Planning Application Ref: P/58/19/PL

Location: Rear of Inglenook Hotel, 253-255 Pagham Road, Pagham, PO21 3QB

Description of works: Erection of 9 No. dwellings with associated access, parking, cycle & refuse storage & landscape design. This application is a Departure from the Development Plan & may affect the setting of a listed building.

Comments on Application:

Inglenook Hotel Appendix 6 - development proposal in relation to RPA

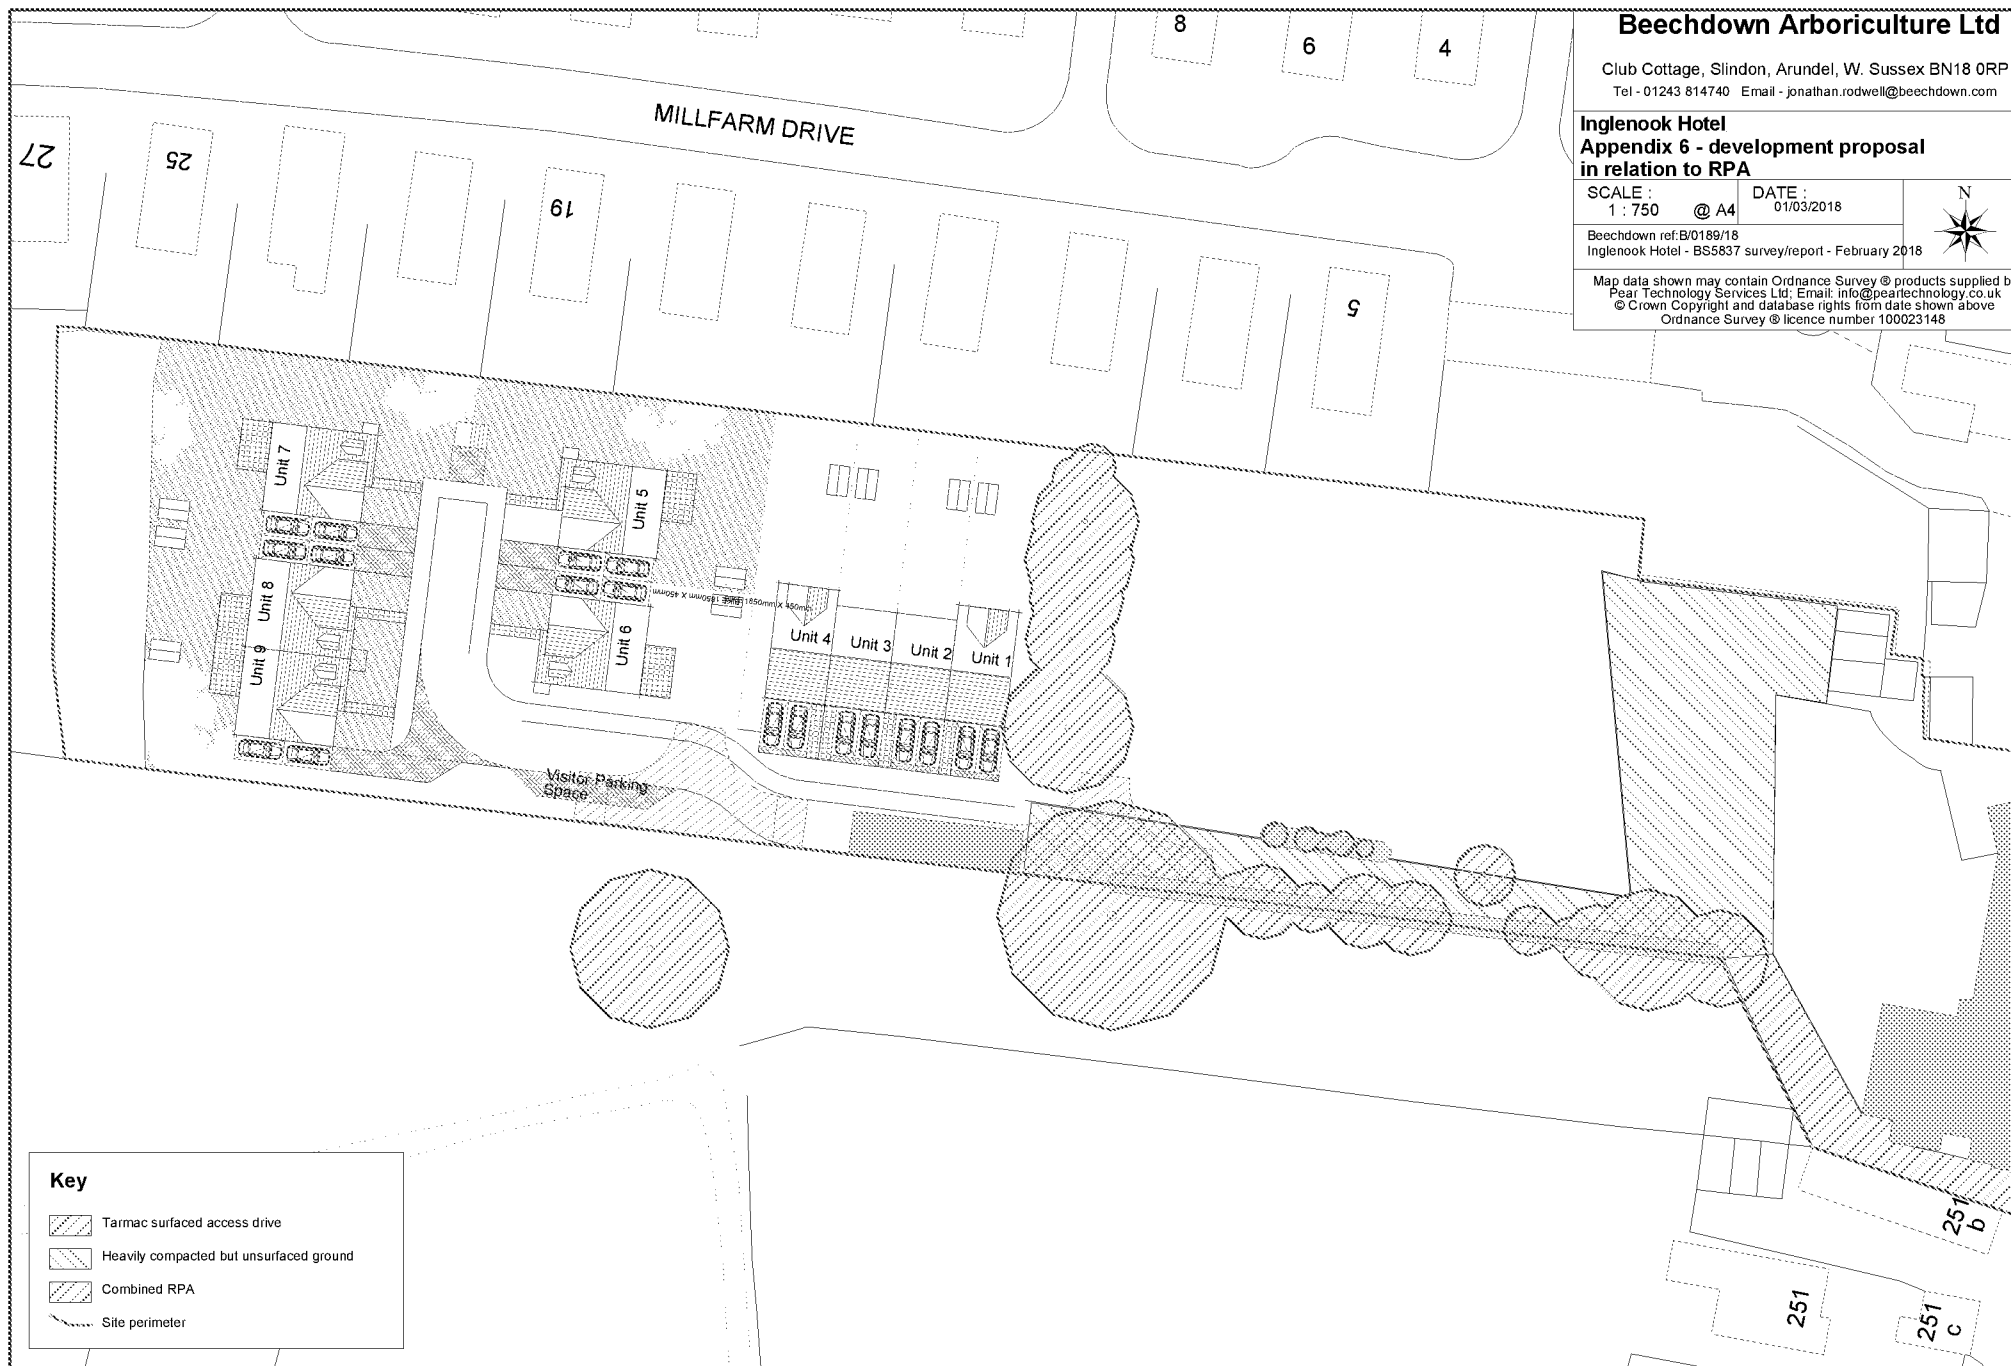
- The hotel grounds to the rear of the building is well populated with trees of varying quality and presents as an oasis of established vegetation when viewed from above and around, providing some visual amenity for the high density of residential dwellings which exist on most aspects. This proposal will effectively enclose said grounds and obscure the view of significant trees (T2, T4-T7).

- There is a clear logic to the proposed layout at first glance and although no trees are proposed for removal (none exist on-site and within the developable area) the root protection areas of those significant trees will inevitably be intruded upon during the construction phase and then subject to compaction over time. Furthermore, the seasonal influence exerted by those trees and especially once they reach full maturity – will inevitably lead to a ‘pressure to prune’ which may prove hard to resist. This in addition to the facilitation pruning required to construct units 1 and 2.

- The site lends itself to a well-thought out development that can accommodate and exploit the landscape potential of maturing trees on its east boundary, and without detriment to the visual amenity they currently provide.
- The proposed layout places undue pressure on and obscuration of, the most significant of trees. I would expect the layout to be revised so as to avoid any construction within or directly abutting the RPA, and visual obstruction of trees (T2, T4-T7).

- As it stands, I must register an **OBJECTION** to this scheme, for the reasons stated above.
- I recommend the making of a Tree Preservation Order in respect of T4 - T7 incl. as described in the application to preserve their place in the landscape and hopefully better inform a revised layout. Please find the relevant TEMPO form and GIS plan to assist you in making this Order at the following location: [REDACTED]
[REDACTED] Please advise both myself and the applicant on the outcome of this specific recommendation.
